MECKLENBURG COUNTY  
Park and Recreation Department

MEMORANDUM

**DATE:** August 23, 2023

**RE:** Rezoning Petition #2023-044  
PID# 04705325

RZ-1

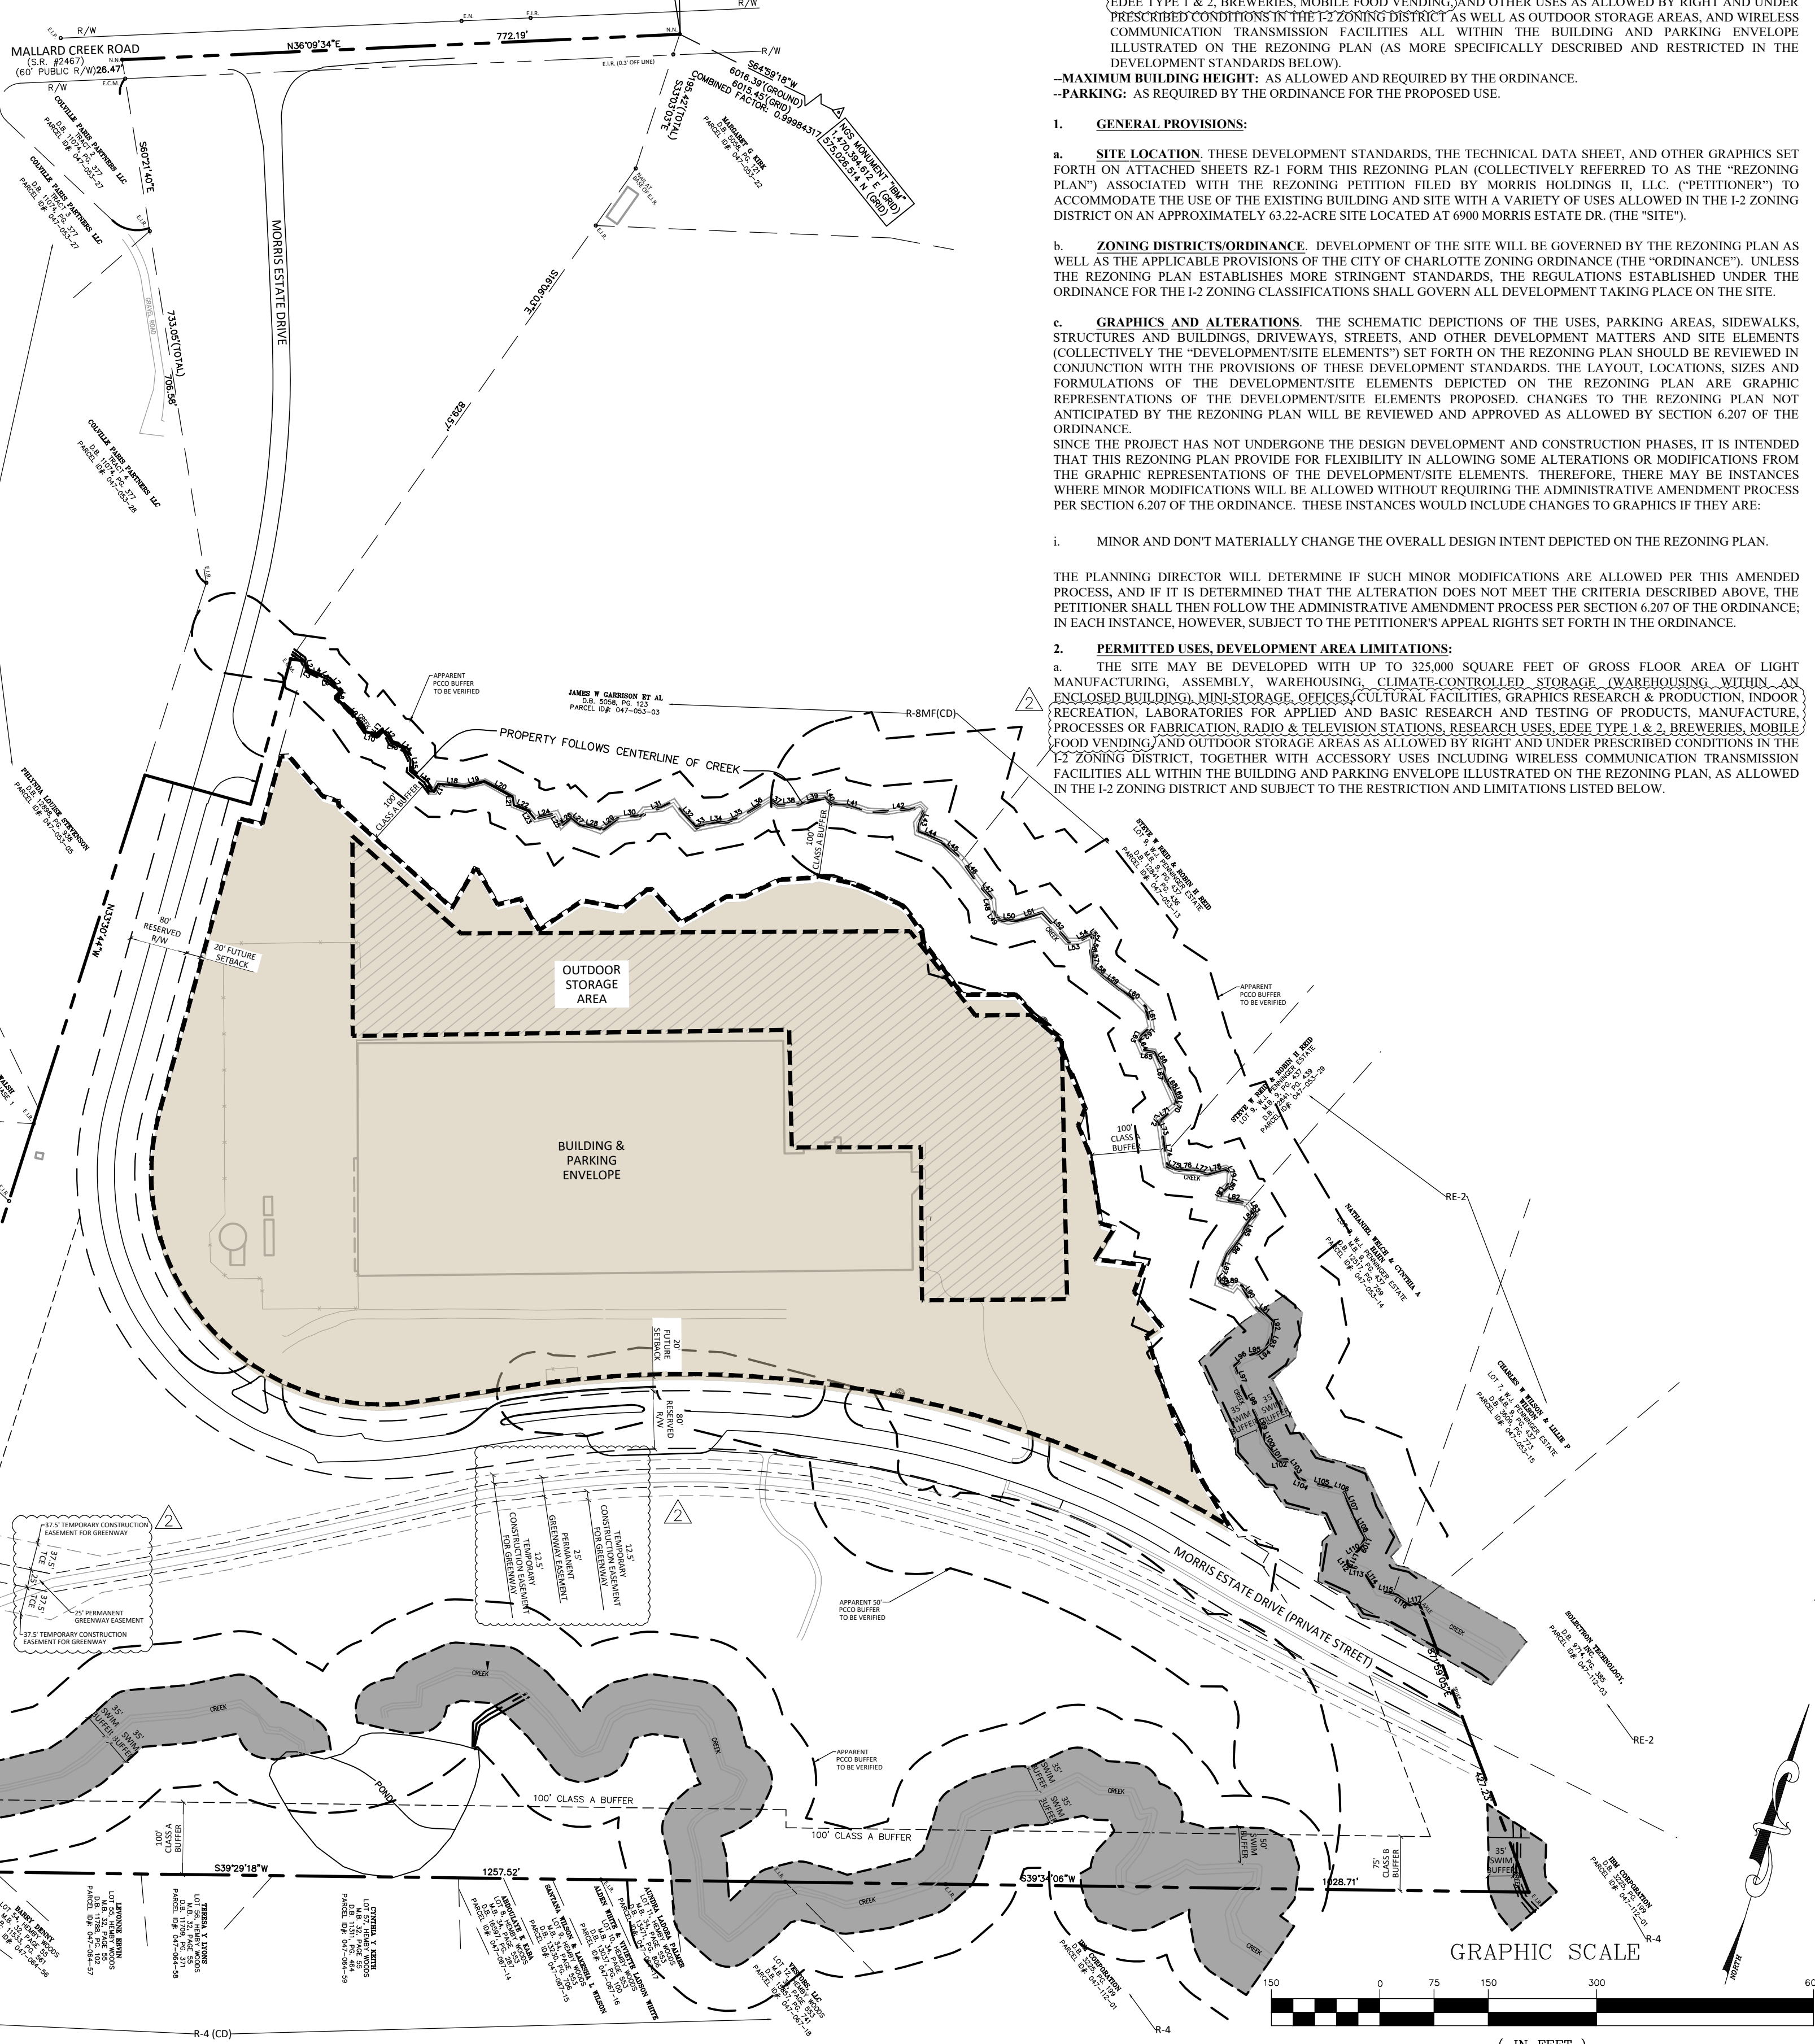
**New comments:** The previous submitted site plan identified the 100' greenway easement area adjacent to Morris Estate Drive. MCPR requests that the proposed easement be consistent with this initial proposed area, with the addition of the connection to Nevin Road as depicted in the Plan Room comment.
